OFFICE OF THE GENERAL MANAGER

9 July 2010

**MAJOR PROJECT MP_0066 – ALBERT AVENUE/THOMAS STREET, CHATSWOOD
(CAR PARK SITE) SUBMISSION TO DEPARTMENT OF PLANNING.**

A-0100 /B  
 PRELIMINARY

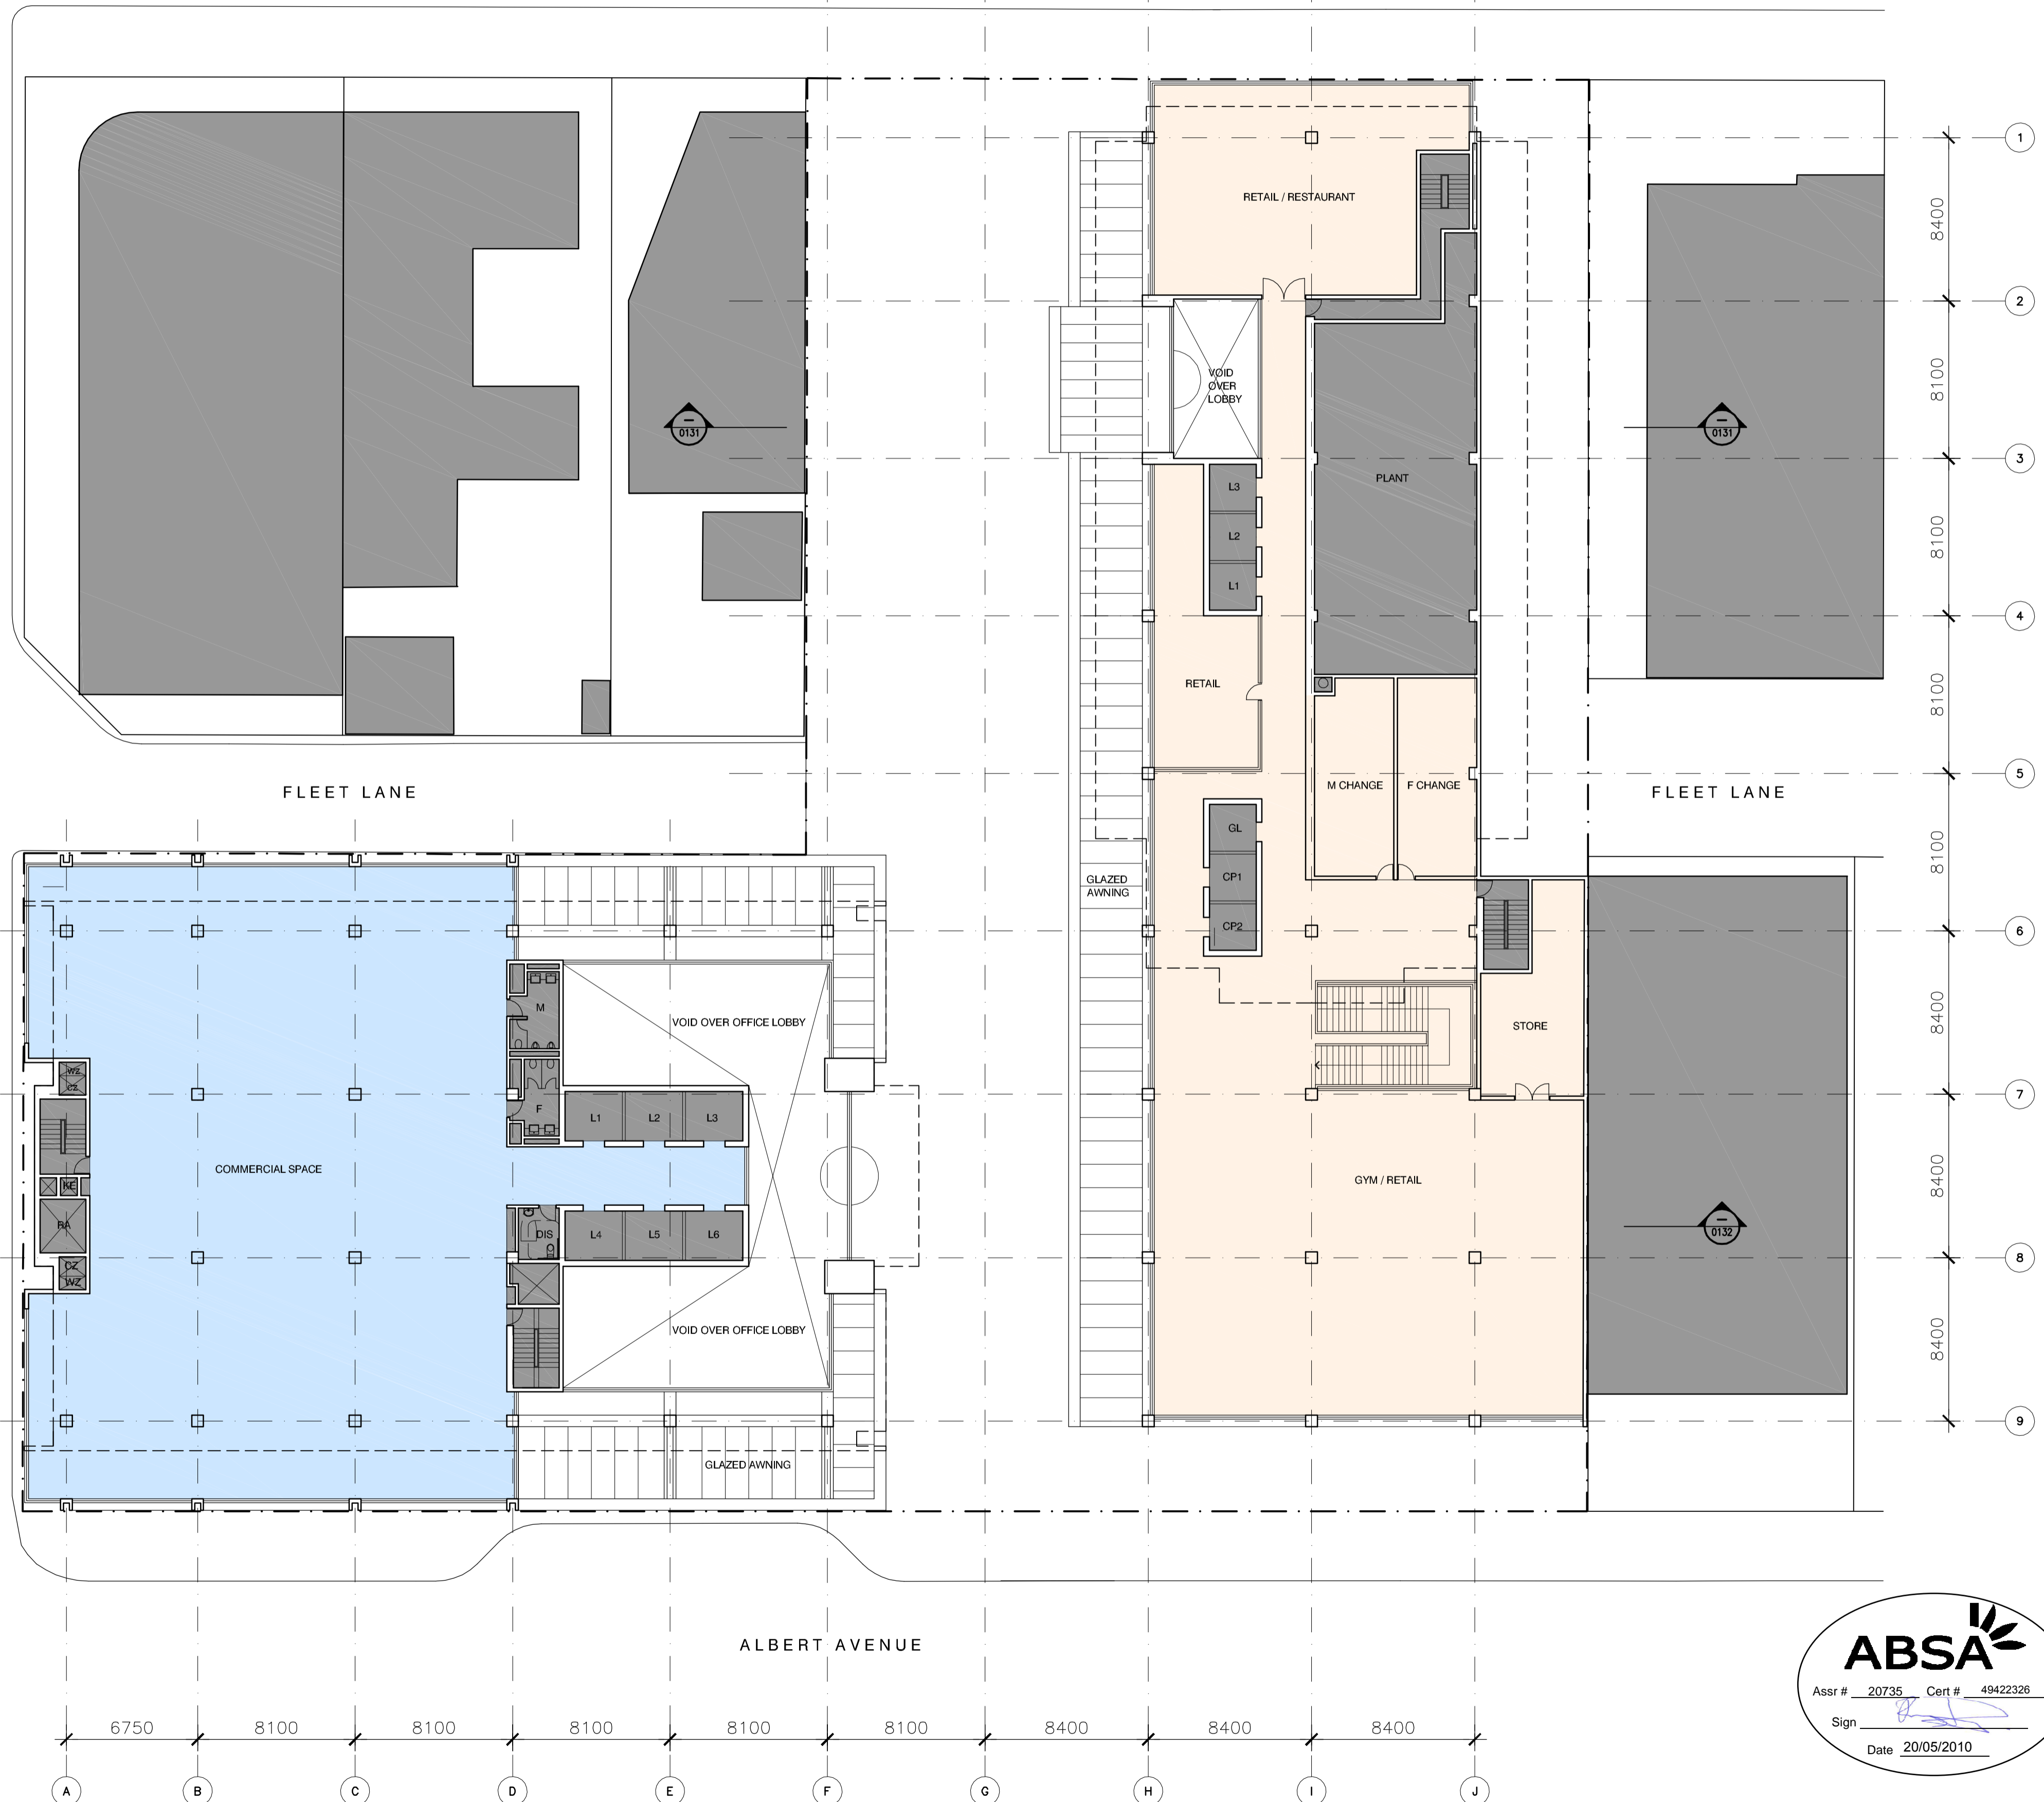
The outcome of this is that the properties backing onto Fleet Lane rely on access to their loading areas and docks from Fleet Lane west. However, the application before the Department provides for closure of the central section of Fleet lane as part of the development site.

Council's submission on the Part 3A project to the Department noted that the application made provision for a new link road along the north-eastern boundary of the site from Thomas Street to Fleet Lane. This will allow car and truck access, once the development is completed, from Thomas Street (approximately opposite Katherine Street) southbound to Fleet Lane and then to Thomas Lane to continue to either Albert Avenue or back up to Thomas Street.

Concerns have been raised with Council from several property owners that rely on Fleet Lane for access that from commencement of excavation and construction until the new link road is available they will be unable to access the rear of the premises to their car parks or loading docks.

- a) implementation of special traffic control measures, or construction by the applicant of an access road, to maintain pedestrian, car and truck access from either Thomas Street, Thomas Lane or Albert Avenue to Fleet Lane east in order to maintain access to the rear of the properties at 73-75 Albert Avenue and 2-12 Thomas Street;

- c) any access road is to be constructed to a minimum standard using road base and bitumen seal pending completion of the new lane linking Thomas Street to Fleet Lane east as shown on the consent plans;
